Name: John Lodge  
Address: 47 Nudgee Rd  
Bonahoe East  
Date: 23 October 2019

**OBJECTION**  
State Significant Development Application No: SSD-10300  
Coffs Harbour Cultural and Civic Space

GORDON ST ELEVATION

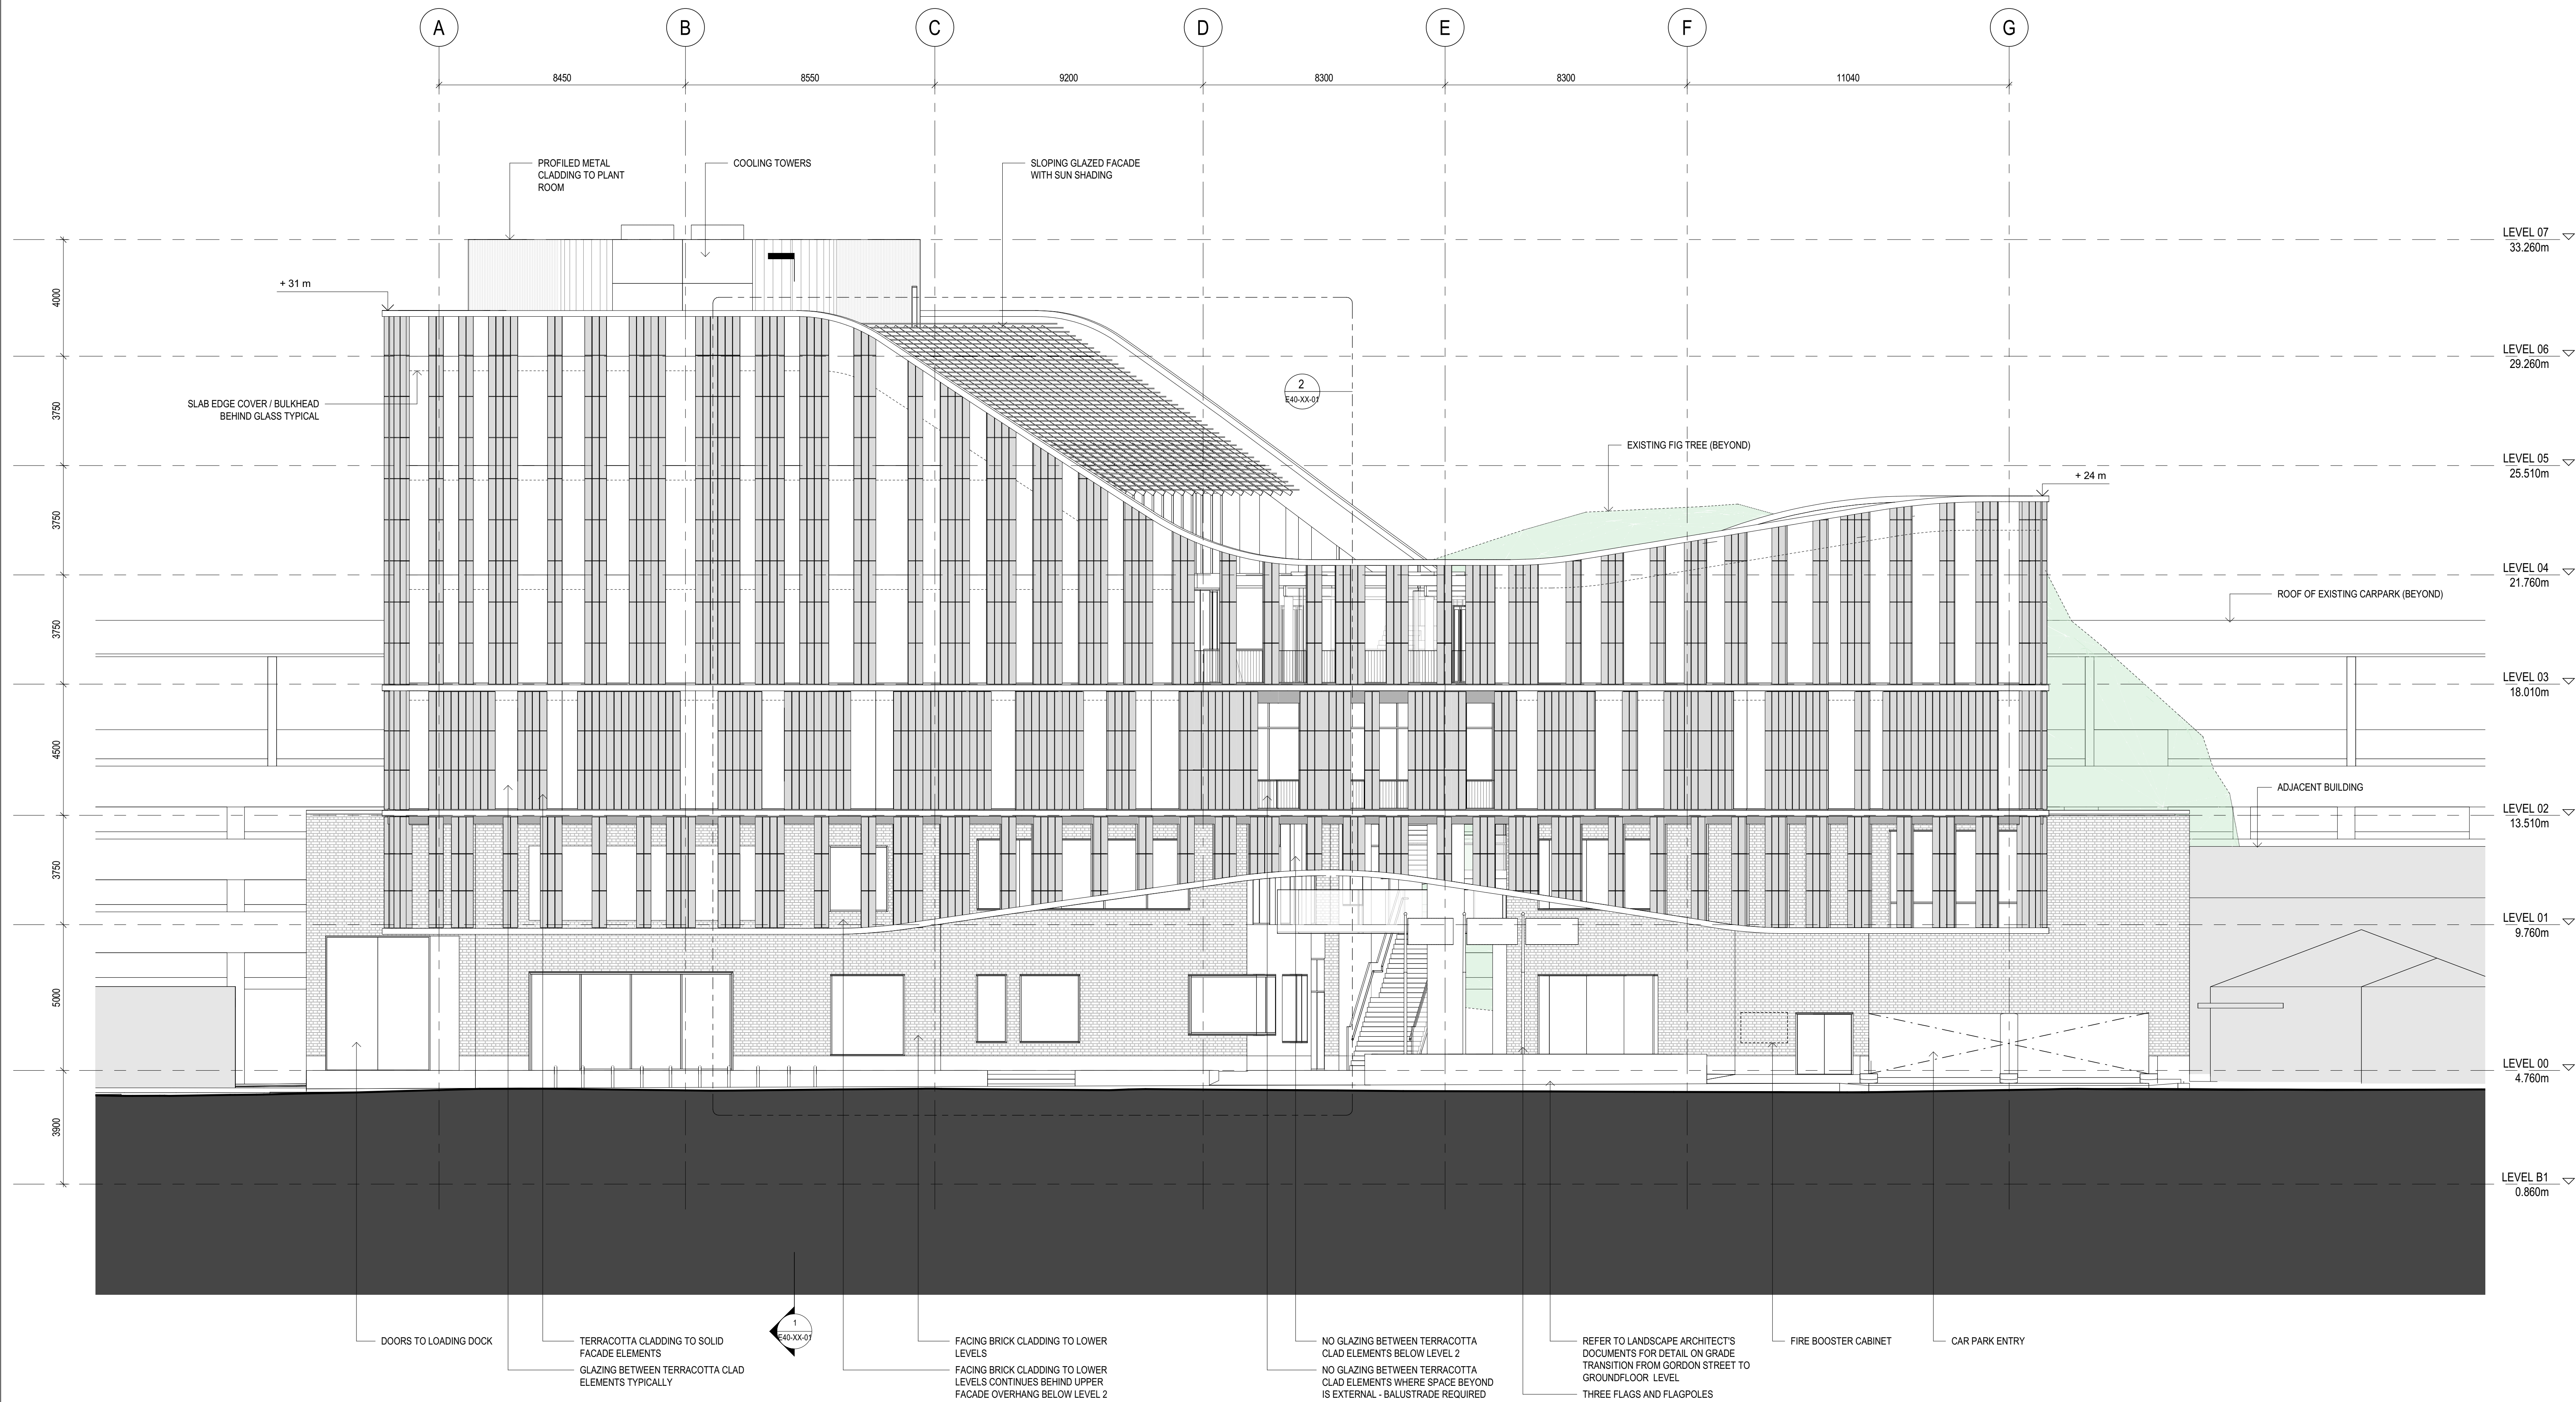
5. The proposed building is out of context in the street with no regard to scale, existing street setbacks, design and general form of adjoining buildings.

RIDING LANE ELEVATION

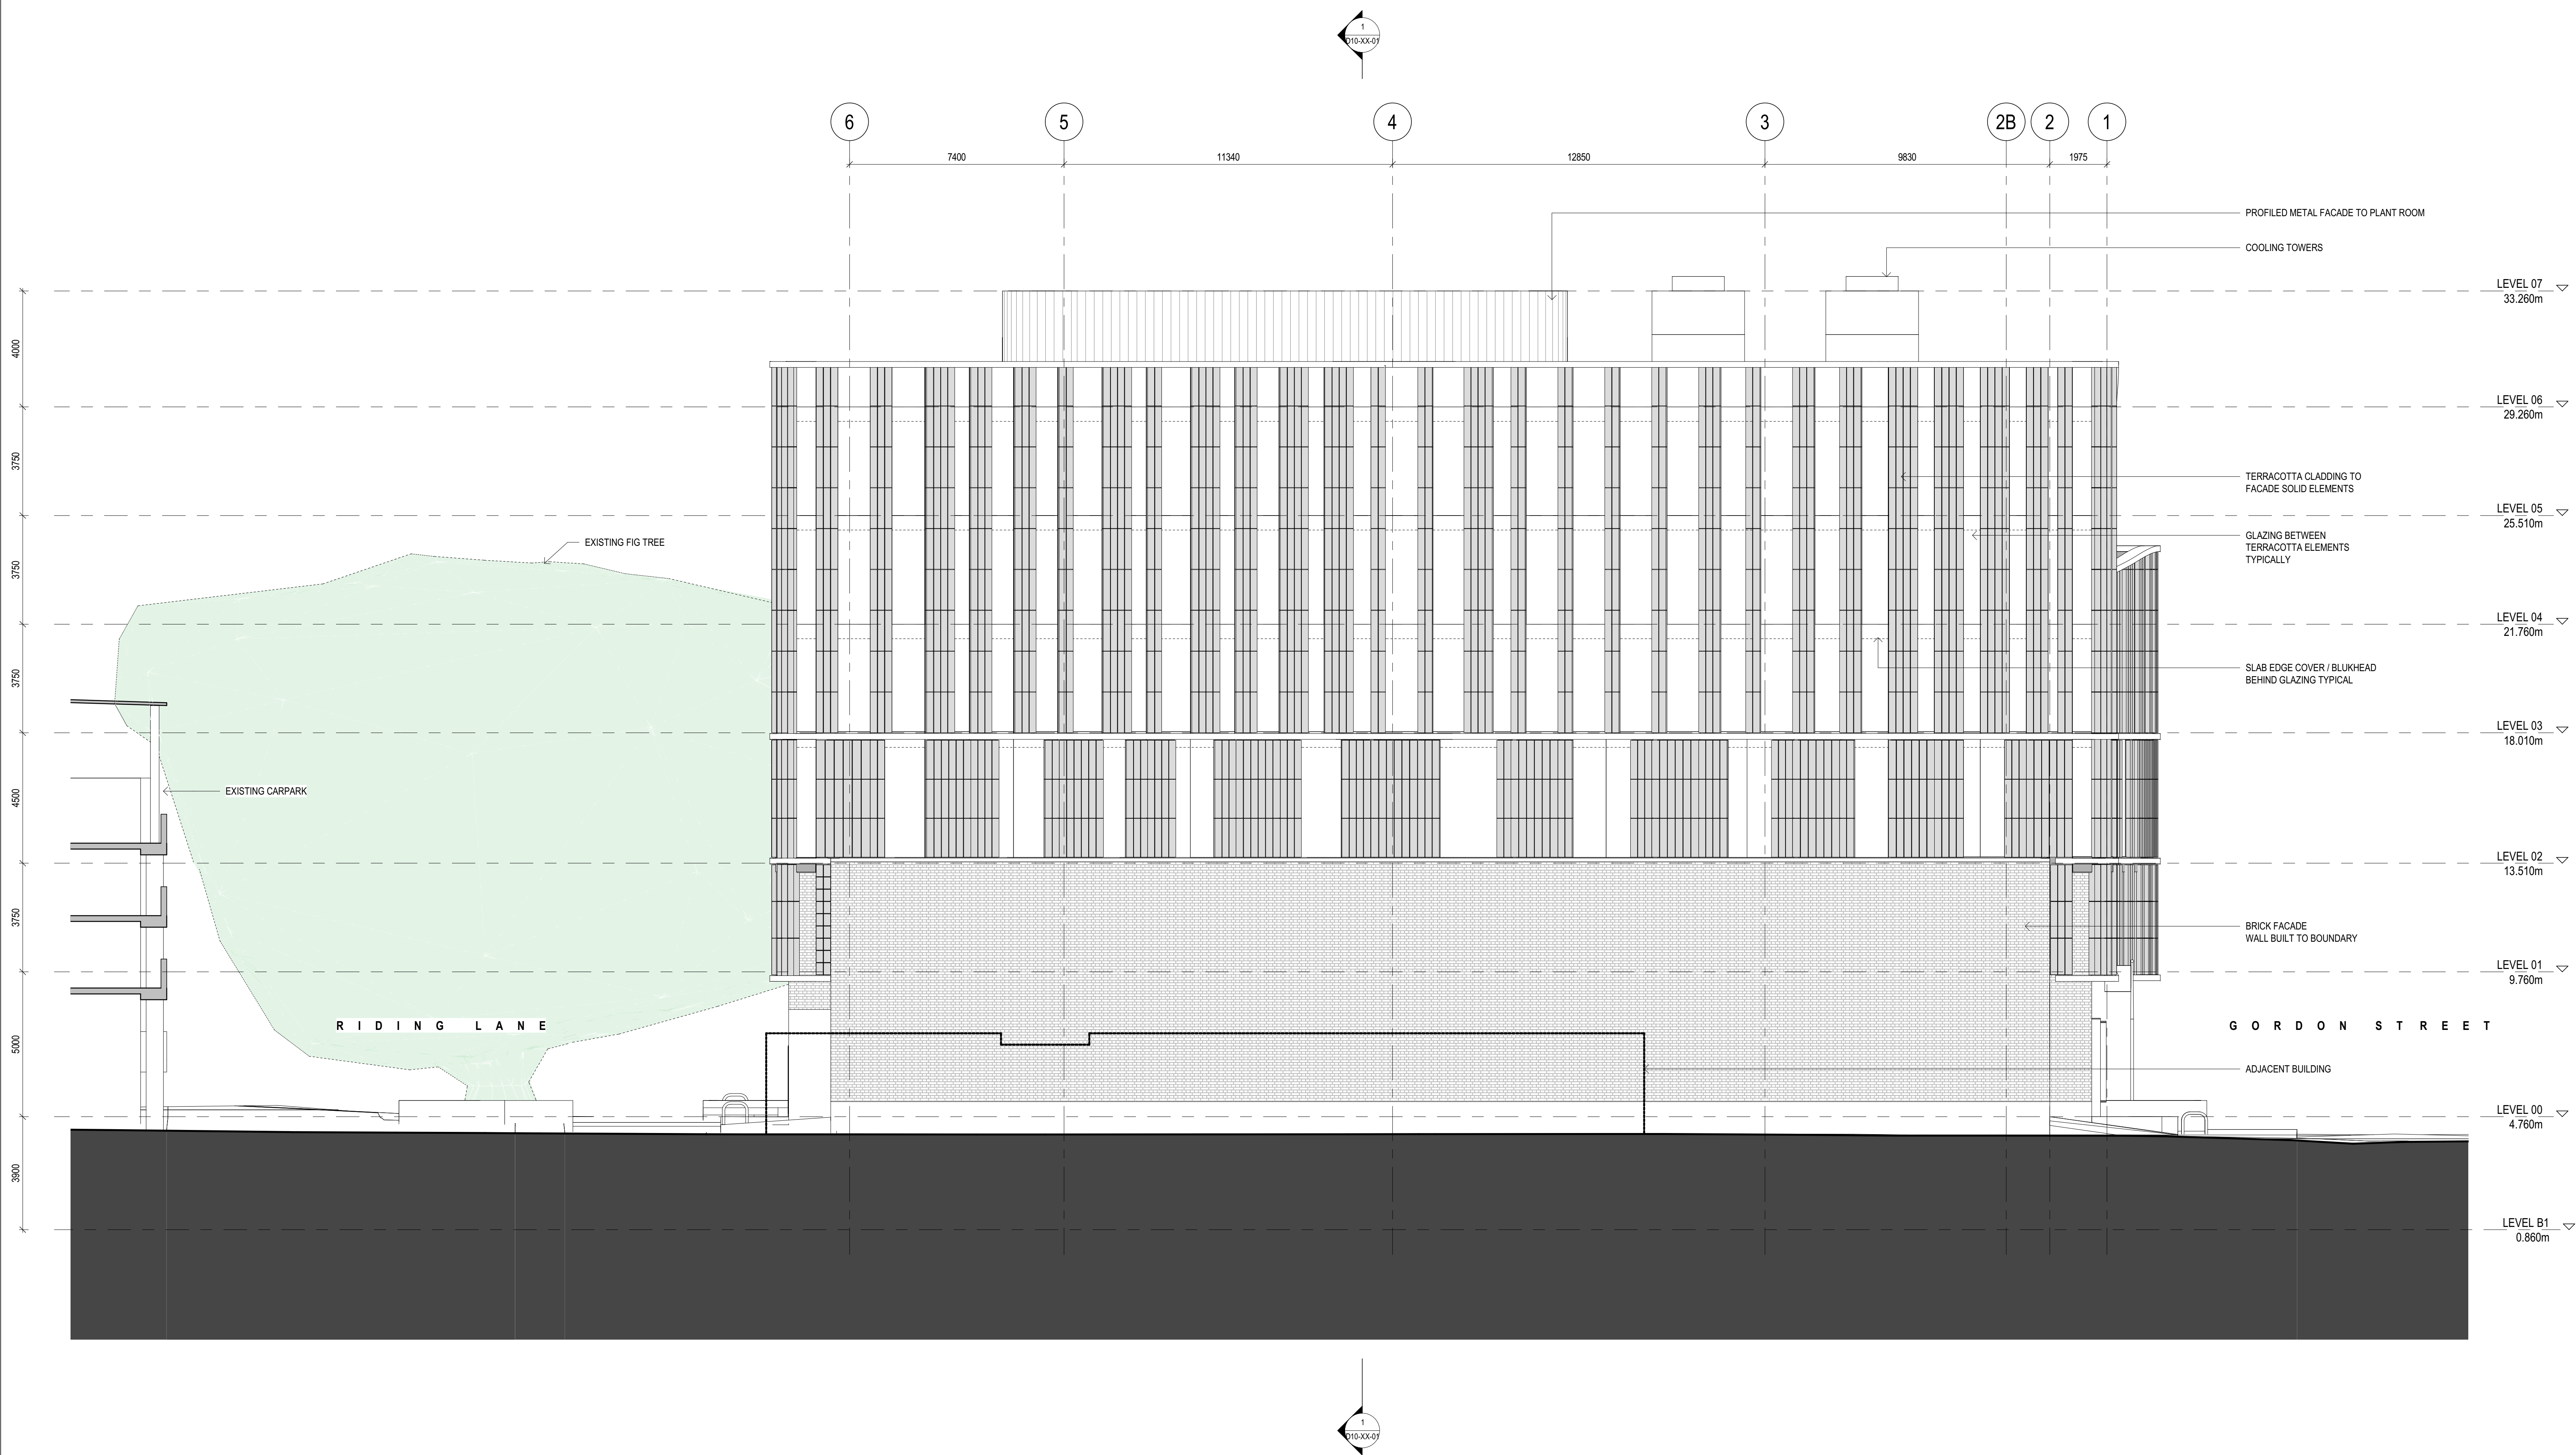
6. The proposal does not meet "safer by design" principles and guidelines, as the arcade to Riding Lane confuses boundaries and provides "hides" for criminal activity, vagrancy and prevents good surveillance.

SECTION N-S

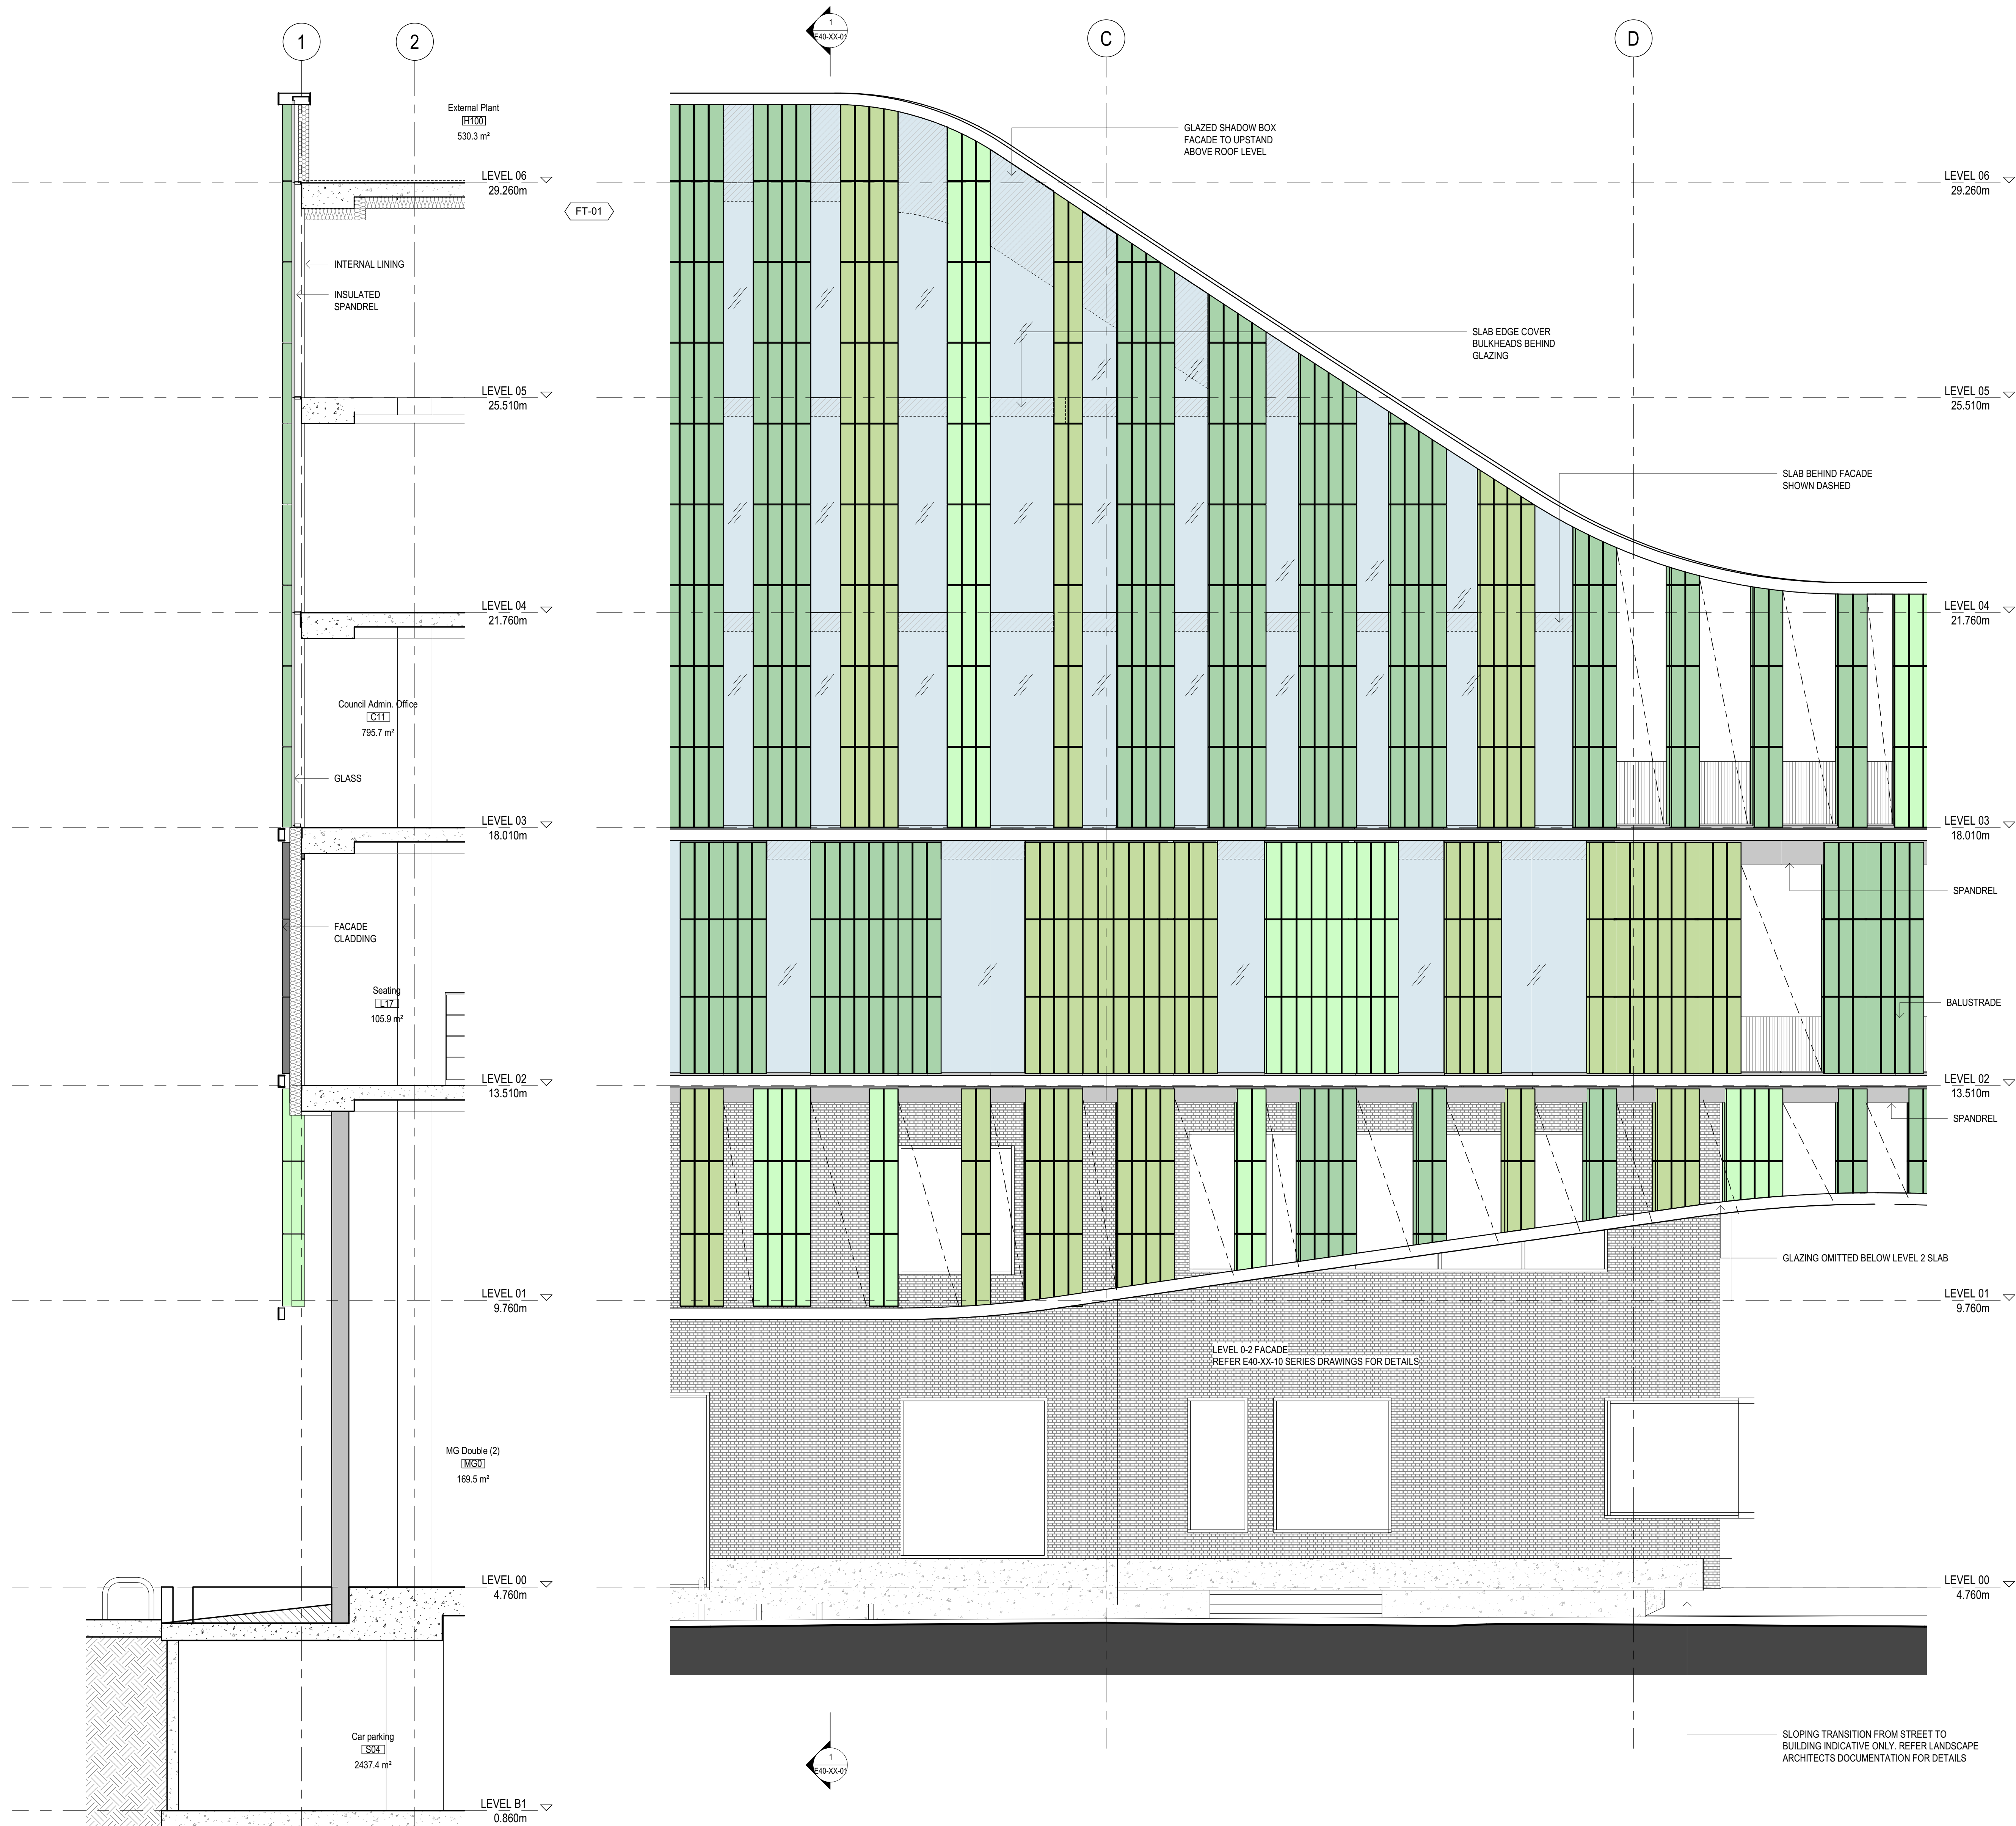
7. As a public building it fails to provide sufficient climate protection for pedestrians during storms and summer sun.
8. The building exceeds the height restriction of 28m set down in Council's own planning controls. Council's argument for variation is not satisfactorily justified and is not consistent with the objectives of the Environmental Planning and Assessment Act 1979, which requires the "the orderly and economic use and development of land". Council should not receive preferential treatment.
